DECISION DELEGATED TO HEAD OF PLANNING

Application No: H09-0843-25 **Applicant:** Mr & Mrs W Van Den Brande
Proposal: Details of doors and windows (Conditions 5 & 6 of H09-0122-25)
Location: Chestnut House North Pennyhill Holbeach
Terminal Date: 30th October 2025

Drawing
CONDITION COMPLIANCE
ALUMINIUM DOOR FRAME DETAILS

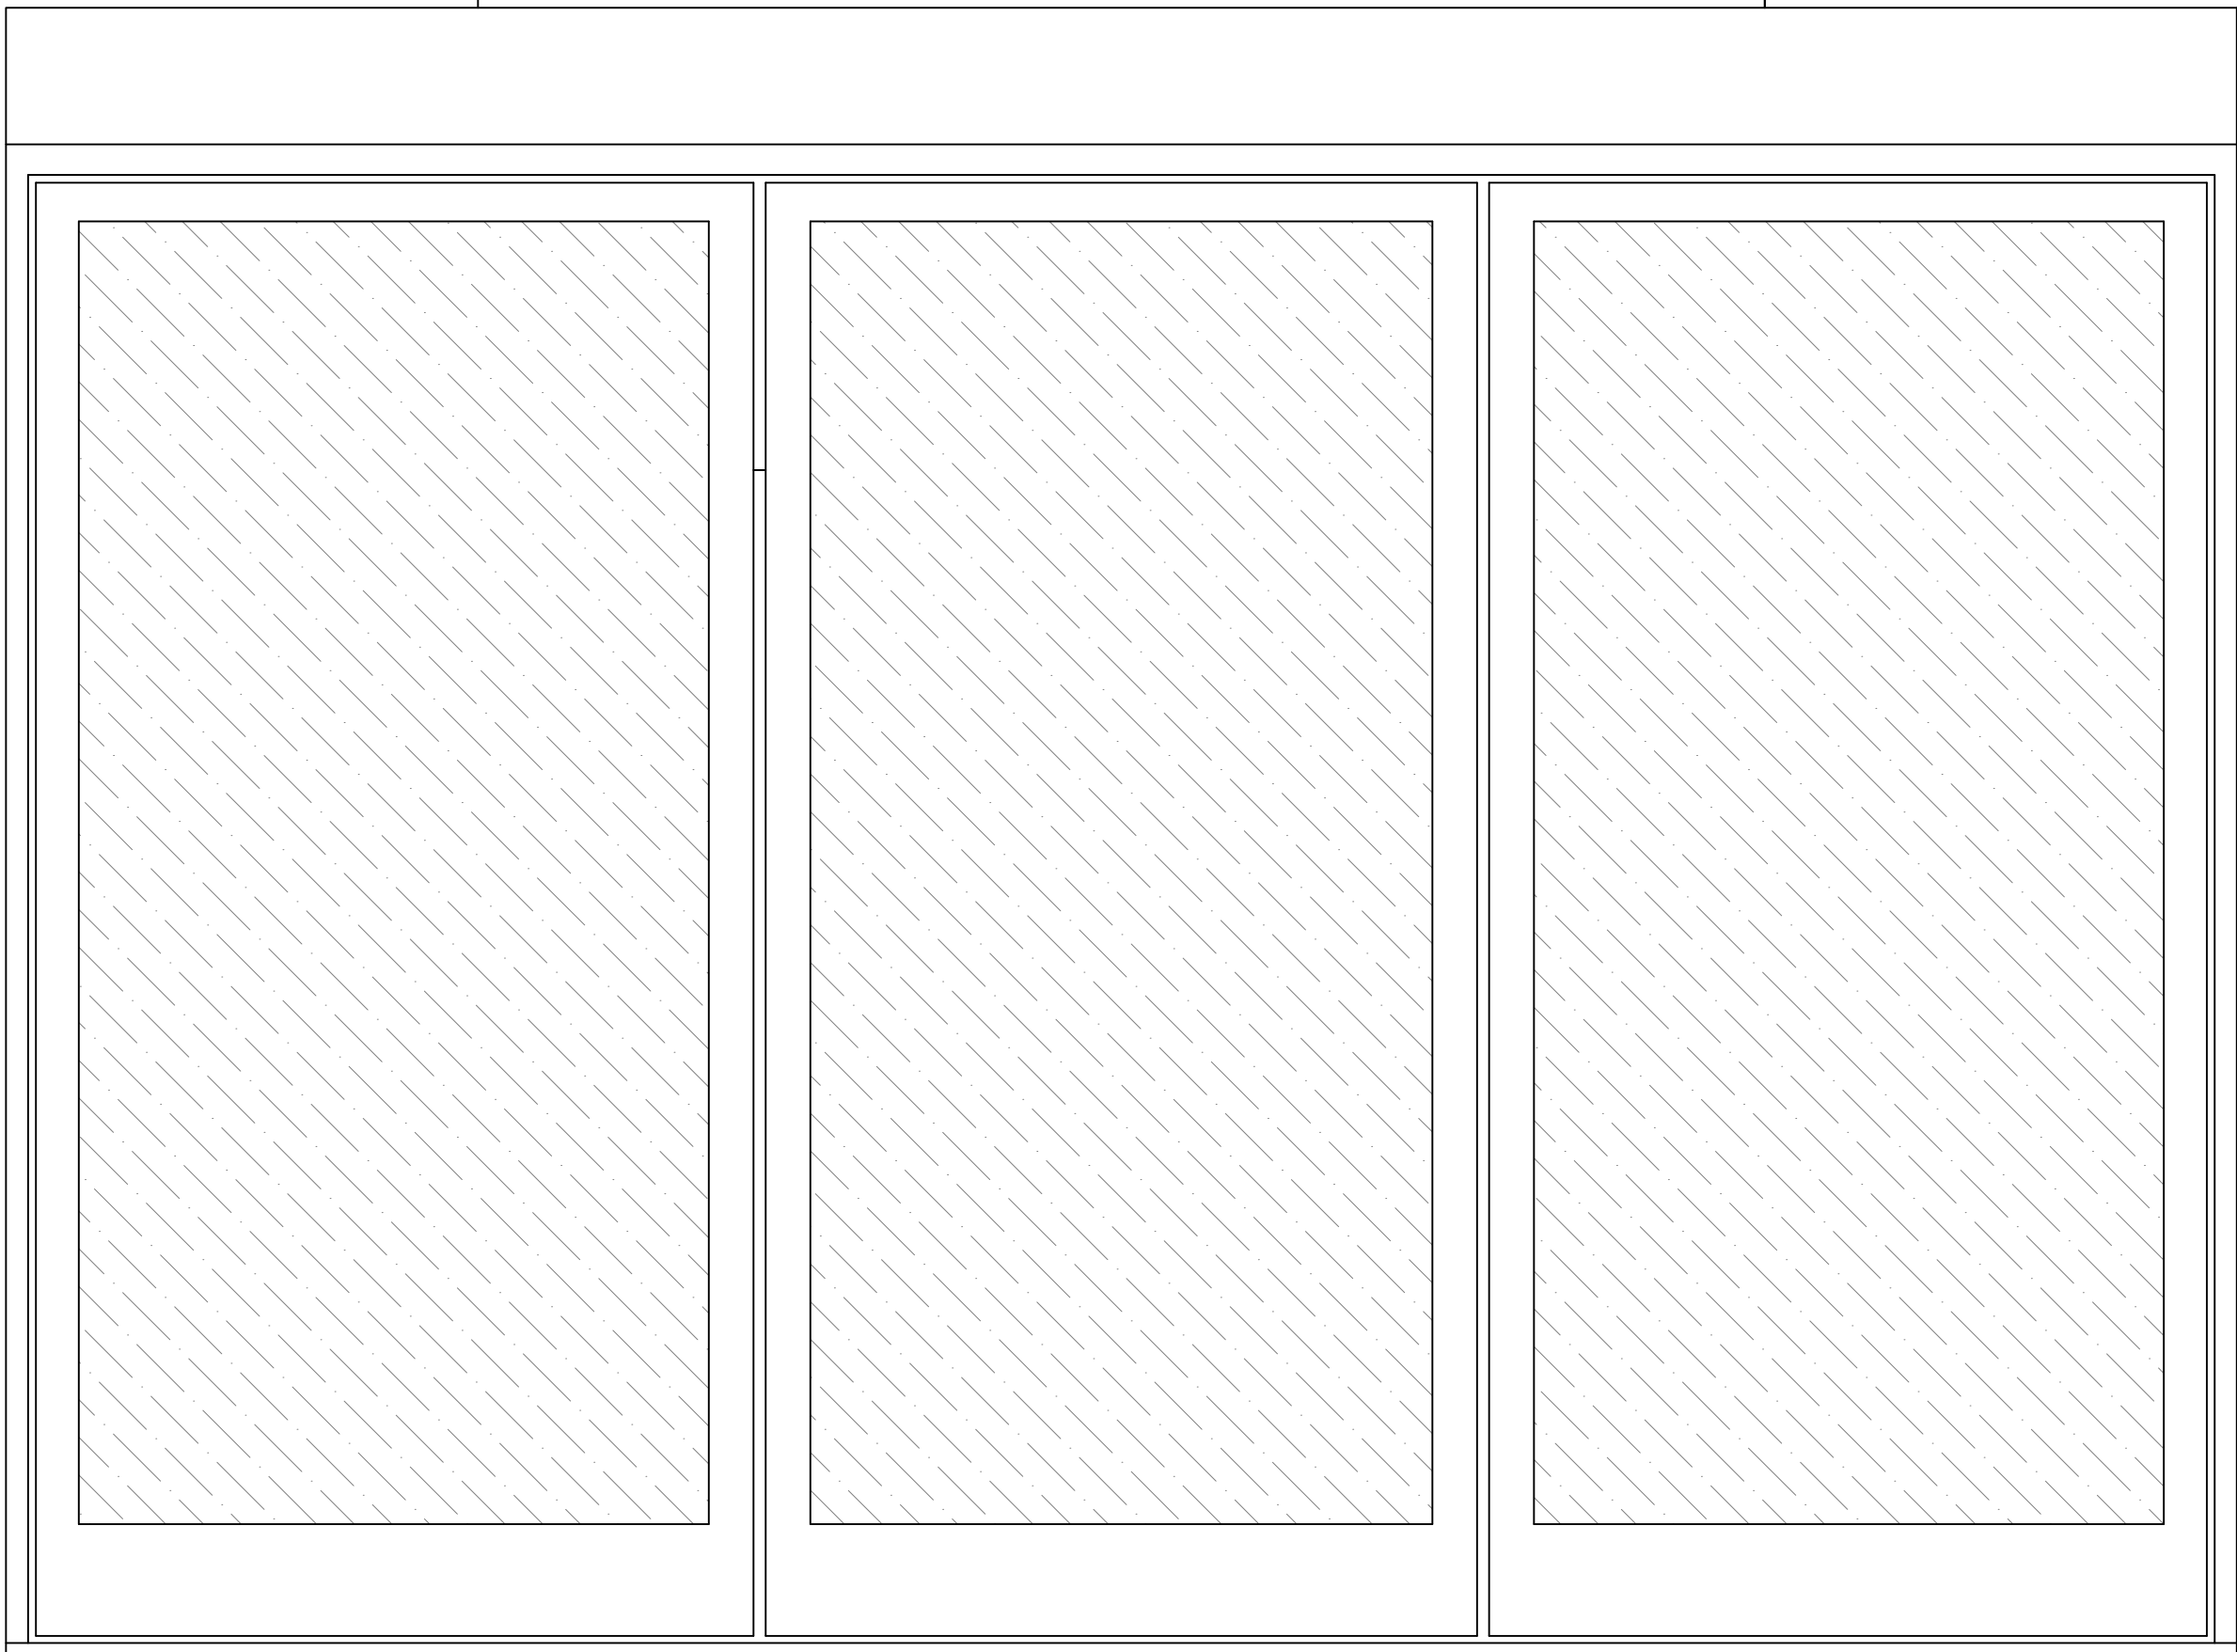
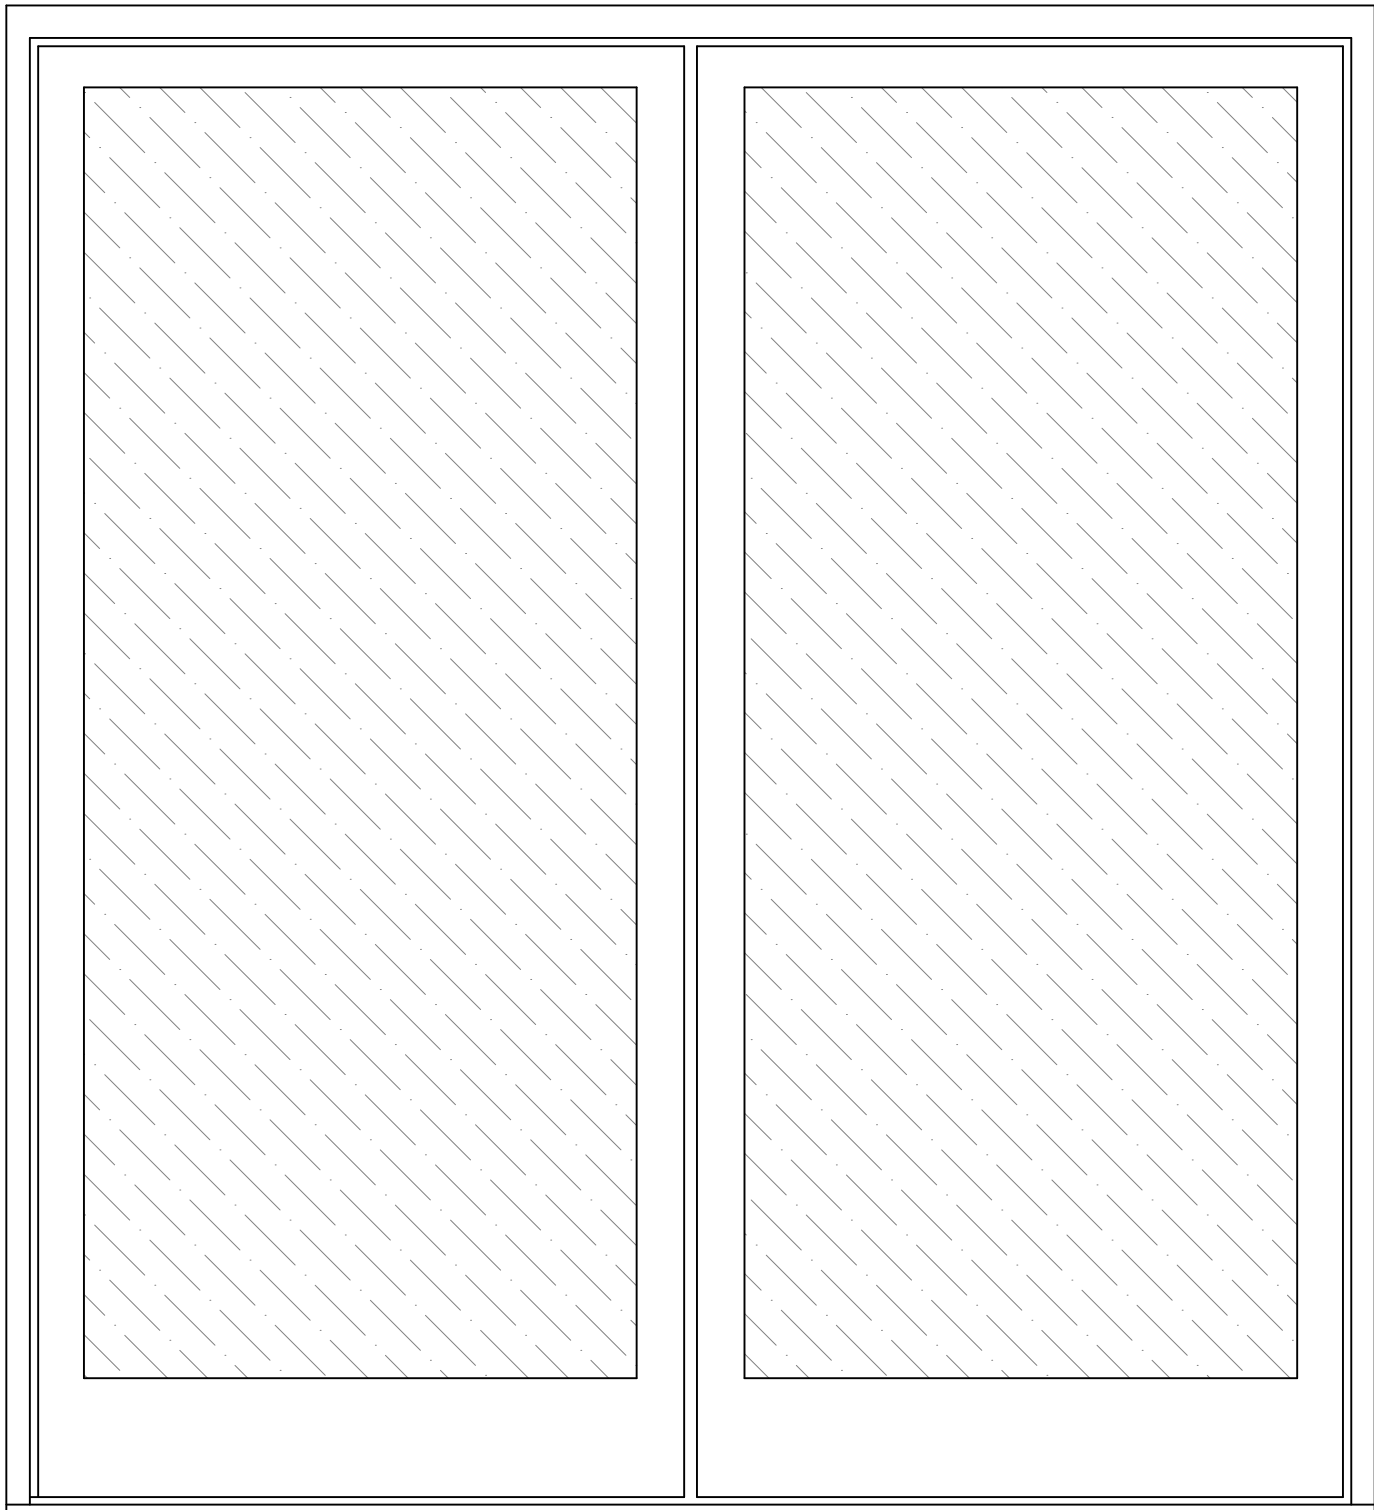
The application is accompanied by plans showing the proposed doors, which are proposed to feature aluminium frames. As set out above, the council's conservation officer has confirmed that the details are acceptable, having an acceptable impact on the grade II listed building within the site. As such, condition 5 can be discharged.

Drawing
CONDITION COMPLIANCE
ALUMINIUM DOOR FRAME DETAILS
ALUMINIUM GLAZED SCREEN FRAME DETAILS

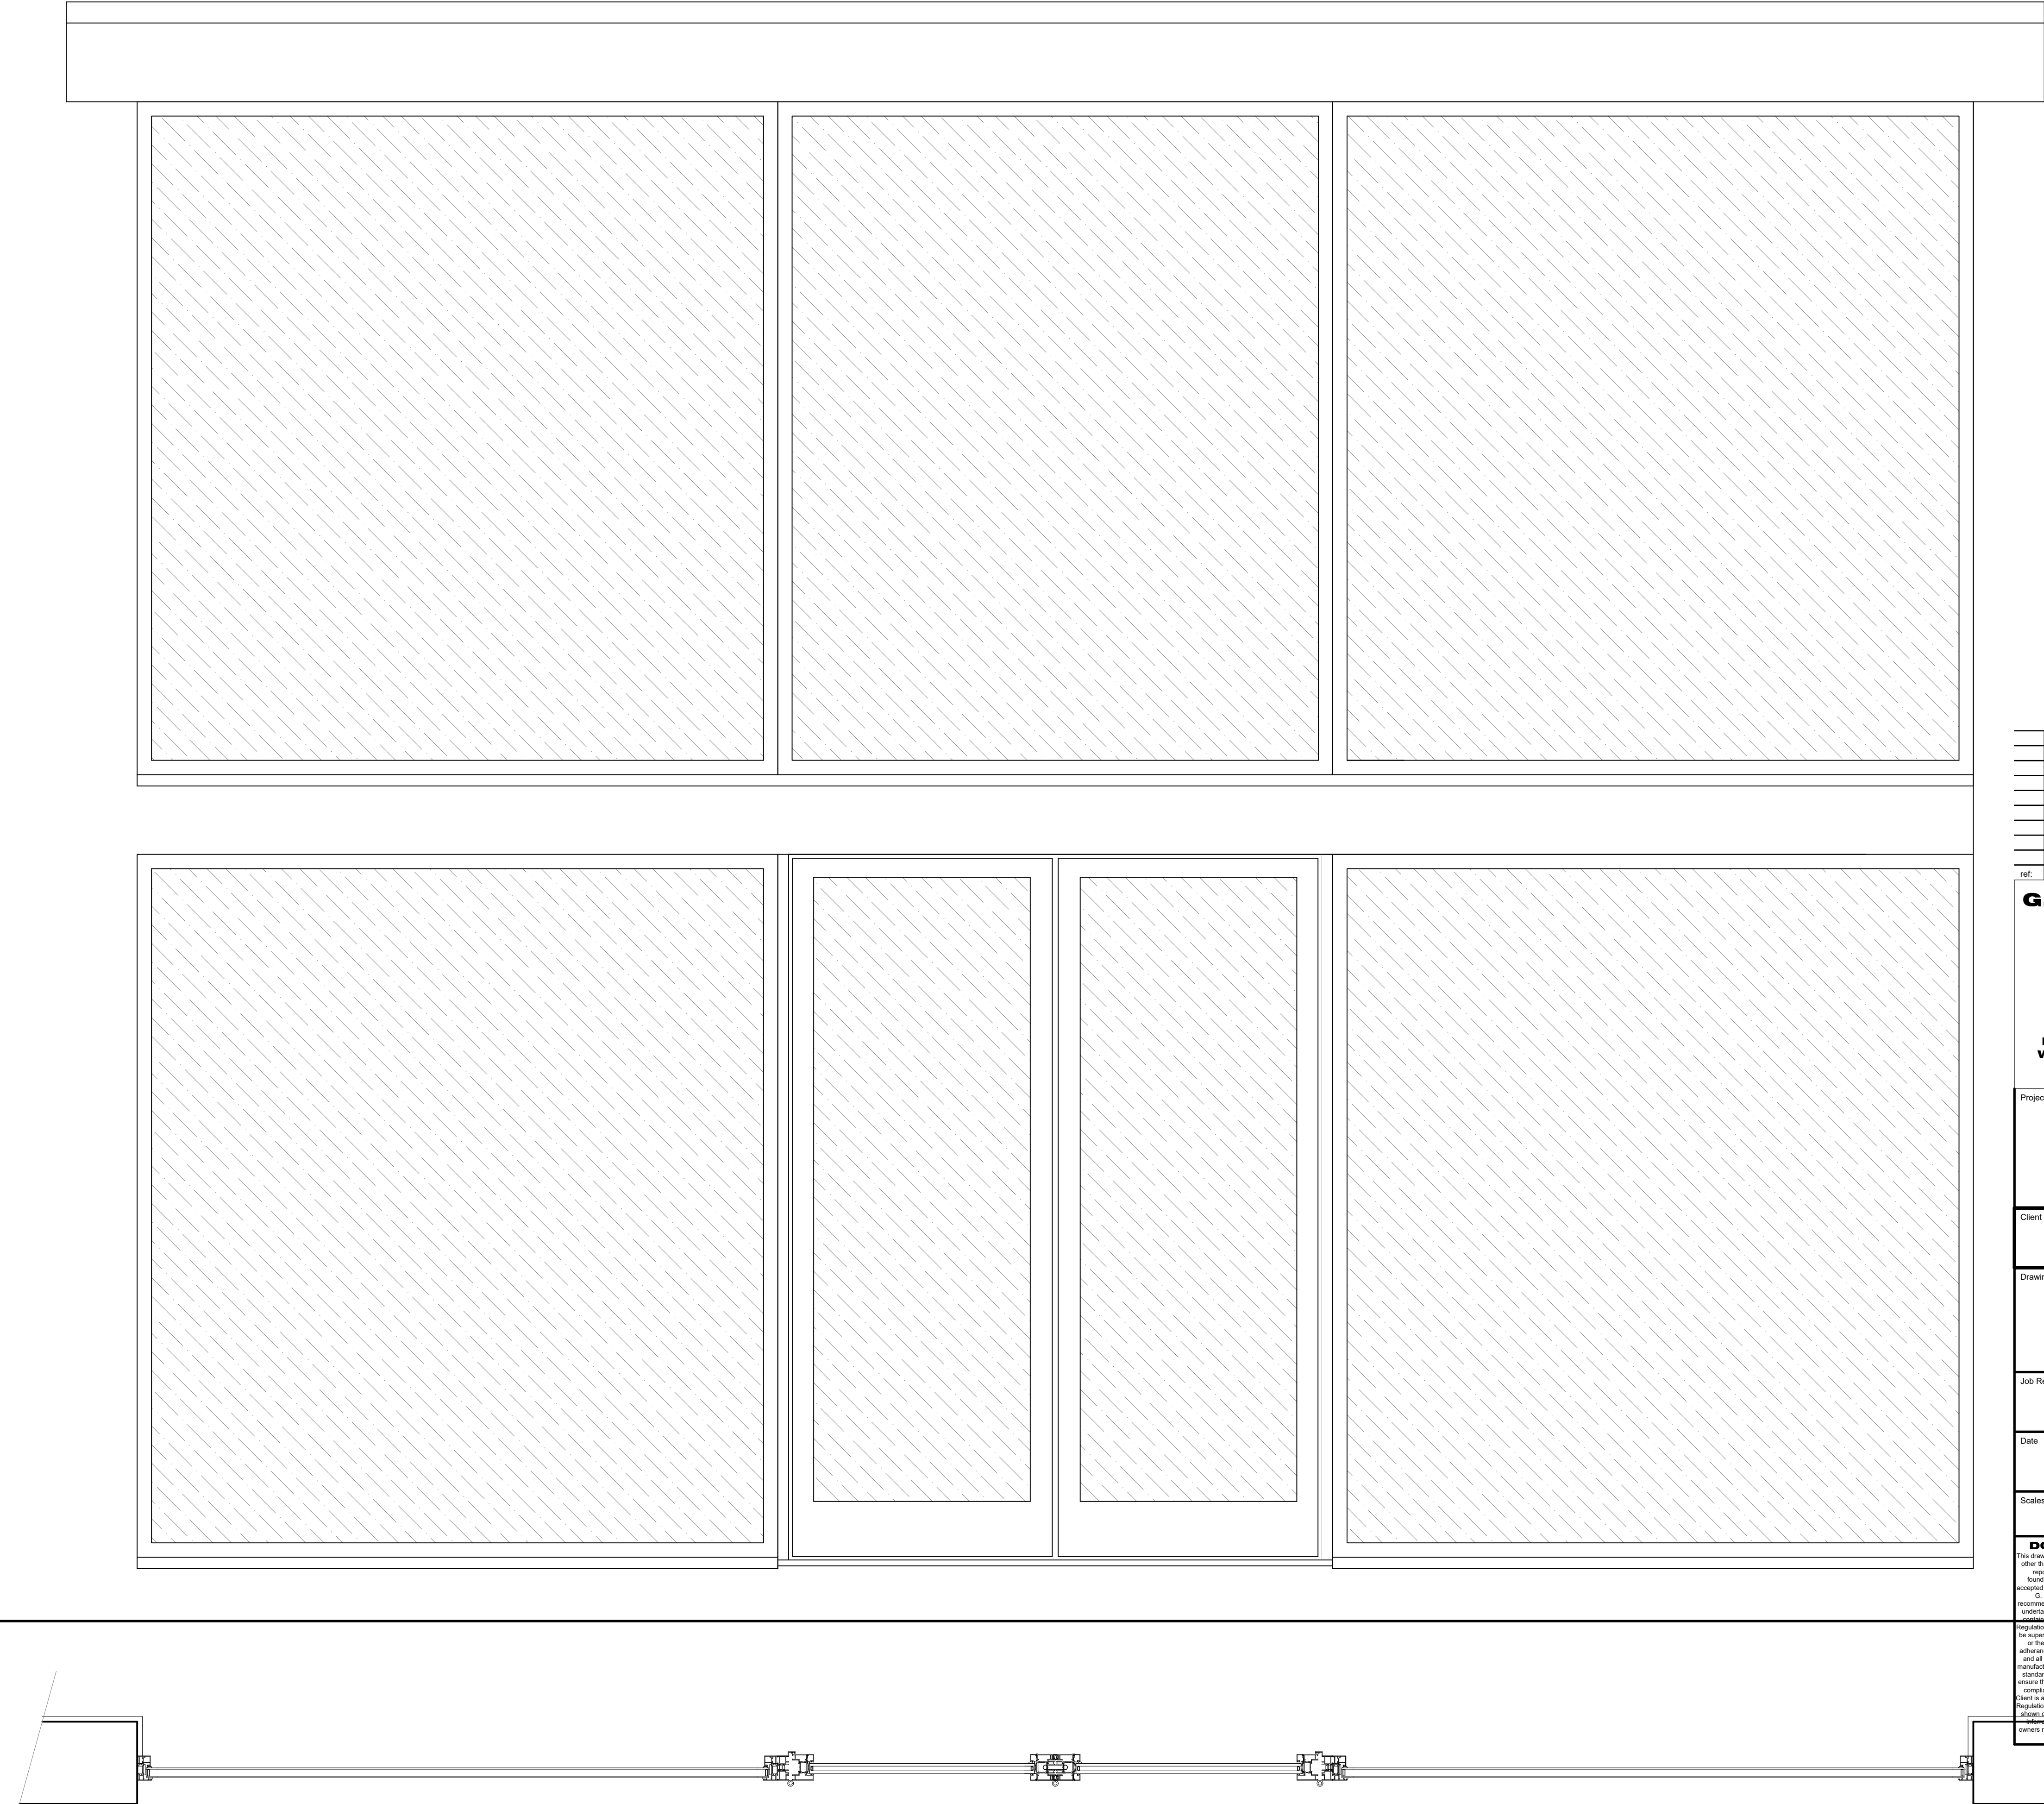
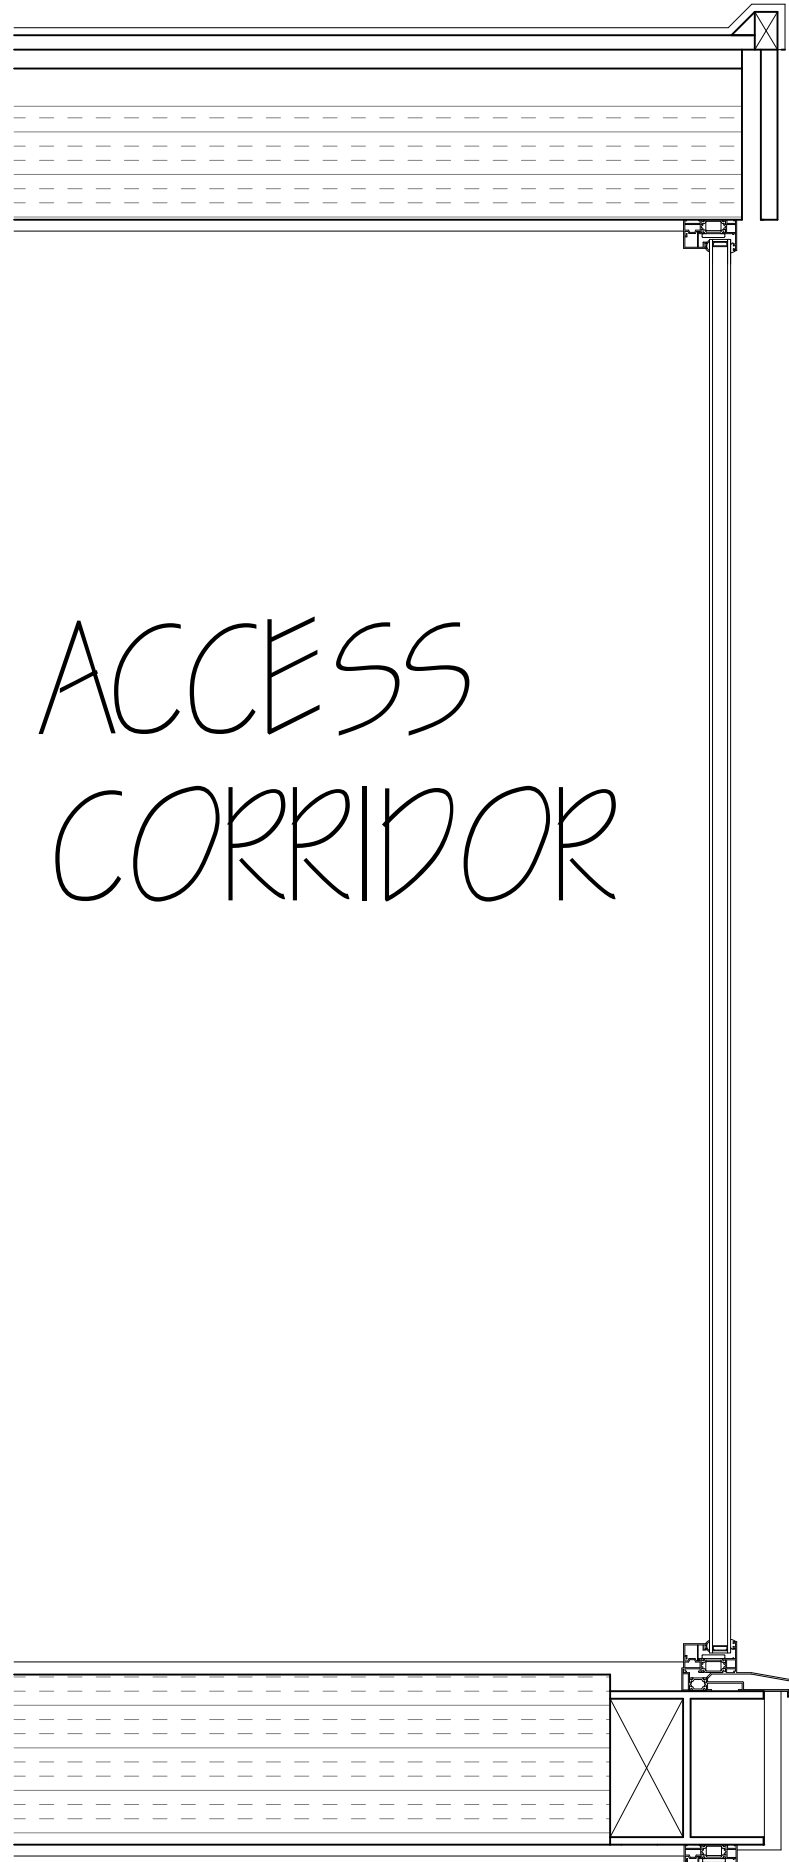
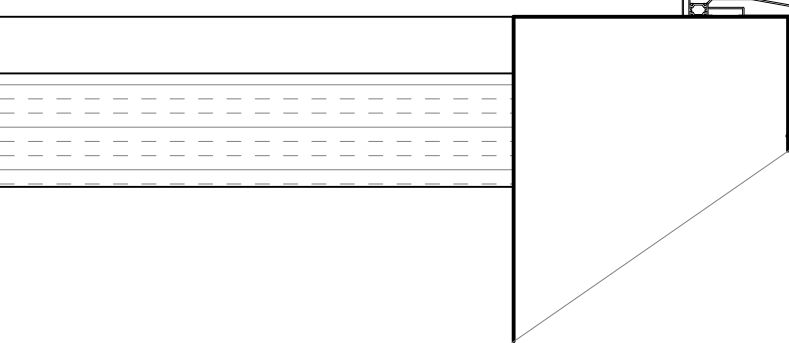
The application is accompanied by plans showing the proposed windows, which are proposed to feature aluminium frames. As set out above, the council's conservation officer has confirmed that the details are acceptable, having an acceptable impact on the grade II listed building within the site. As such, condition 6 can be discharged.
